**KIRKLEES METROPOLITAN COUNCIL
INVESTMENT & REGENERATION SERVICE**

**DELEGATED DECISION TO DETERMINE APPLICATIONS FOR
CONSENT, AGREEMENT OR APPROVAL REQUIRED BY CONDITION**

Reference No:	2025/44/93158/E
Site Address:	Grange Moor Coachworks, Barnsley Road, Grange Moor, Huddersfield, WF4 4DR
Description:	Discharge of details reserved by conditions 4 (external facing materials), 15 (CEMP), 32 (charging electric vehicles) on previous permission 2023/90668 for demolition of existing buildings; erection and operation of single building comprising Sui Generis land use limited to the purpose of storage, assembly, sale and distribution of custom-built computers, laptops and their components as well as any associated development (those being replacement wind turbine, utility provision, drainage, access, hard and soft landscaping) within the red-line boundary alongside business operations pursuant to the effective administration of the Sui Generis use
Recommending Officer:	Farzana Tabasum

Officer Report

Figure 3 PowerPanel

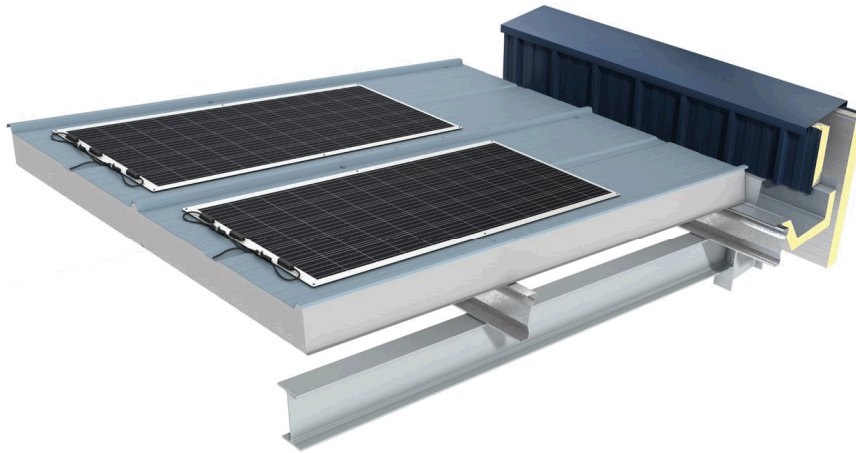
K.C. Conservation and Design expressed concerns within their comments dated 19/12/2025 over the solar panels, specifically their inclusion of silver coloured lining. Following this feedback to the applicant a more muted product

that addresses this concern, which is acceptable to officers and considered to address K.C. Conservation and Design's initial concern
